Application for Planning Permission for Works or Extension to a Dwelling

Development: Detached garage to front garden. Infill extension linking main house to existing garage and part conversion of existing garage to Home Office
Location: 148 Littlehampton Road Ferring BN12 6PH

Drawing No. 25/148/4 ^A

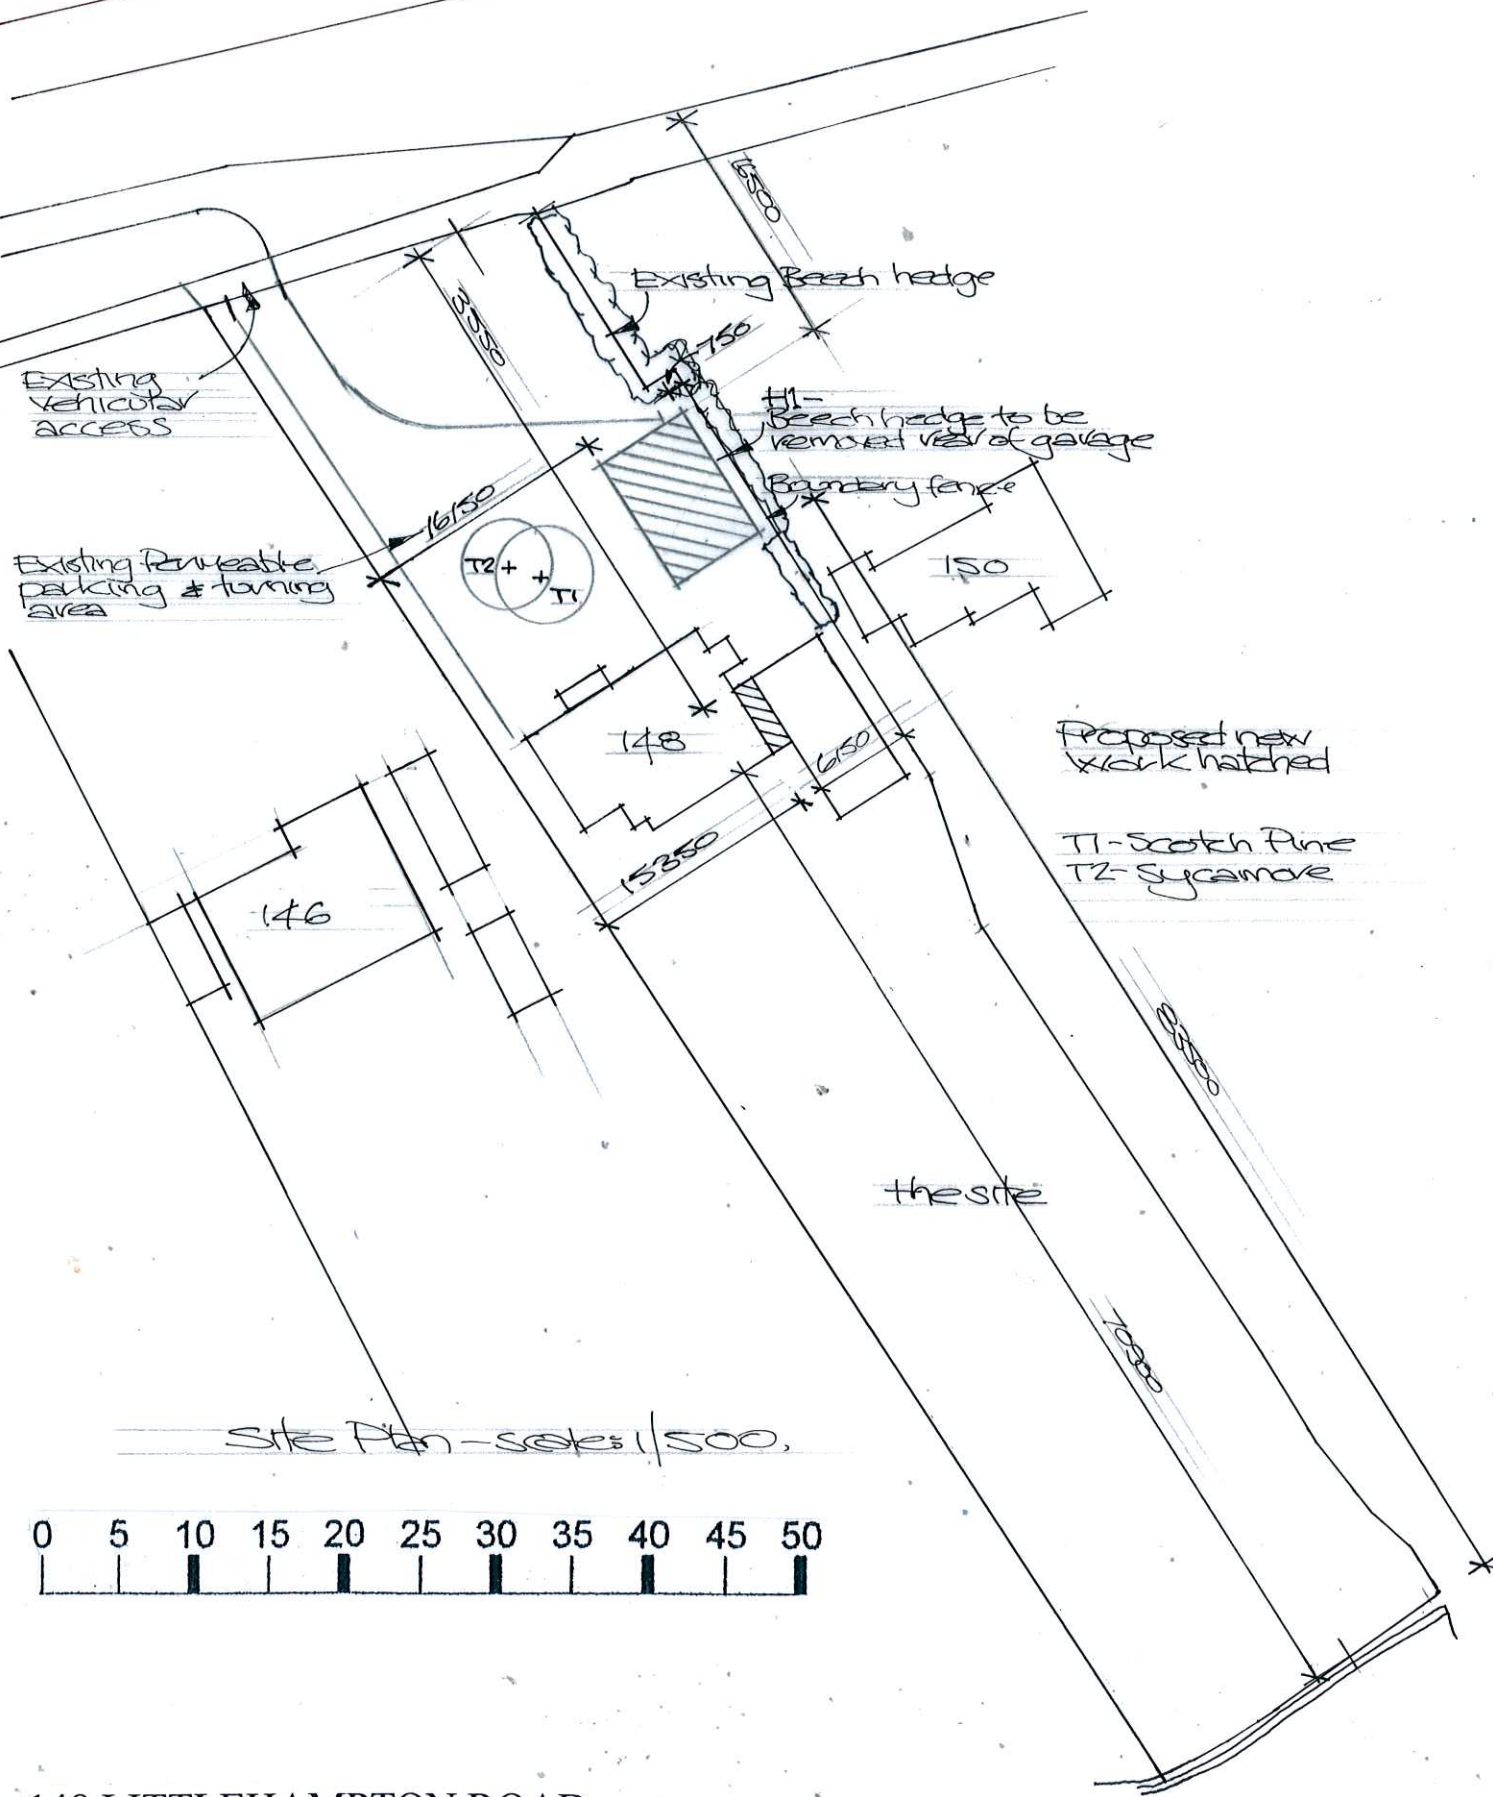
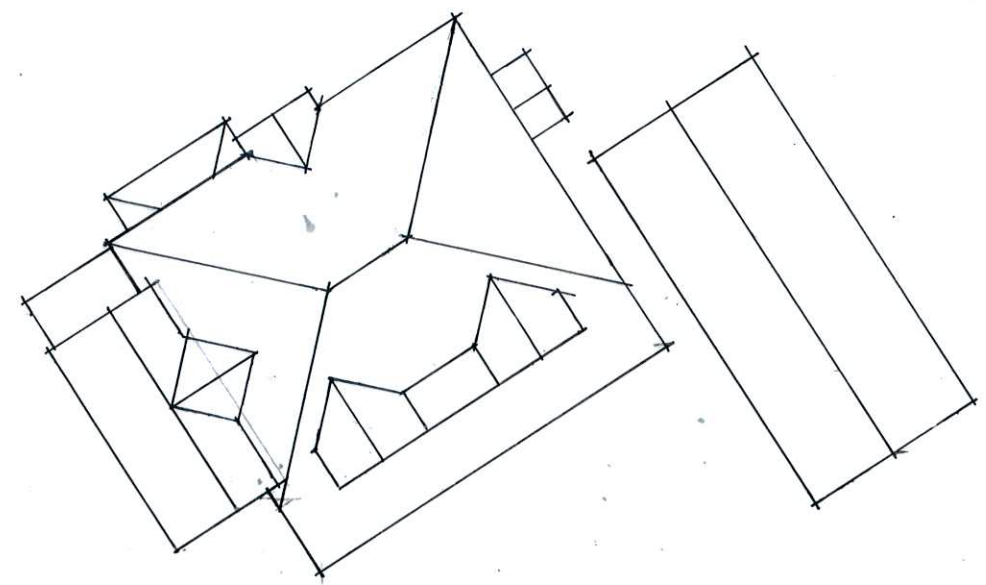
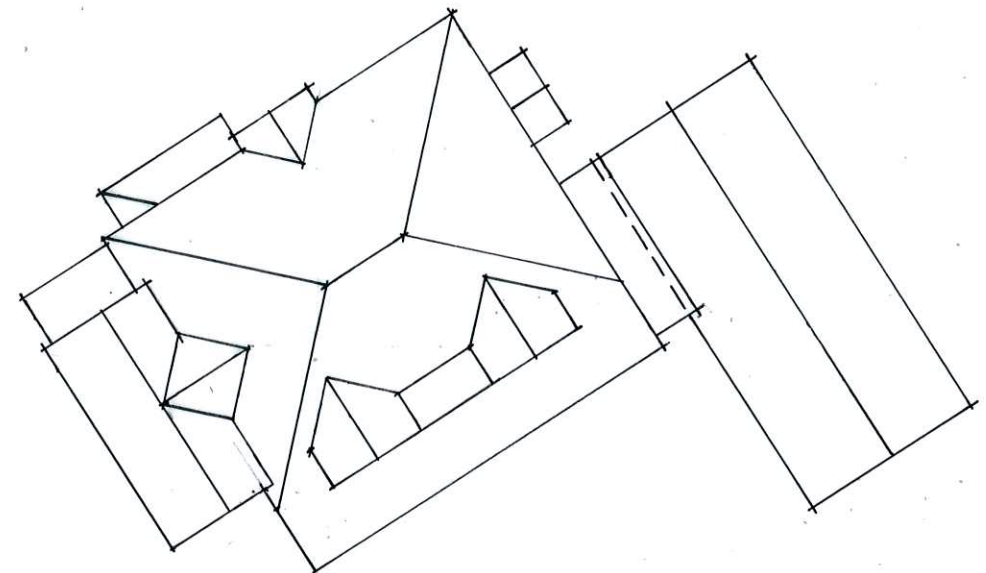
Block Plan

You are required to have dimensions from the proposed extension(s) to all site boundaries. Please amend.
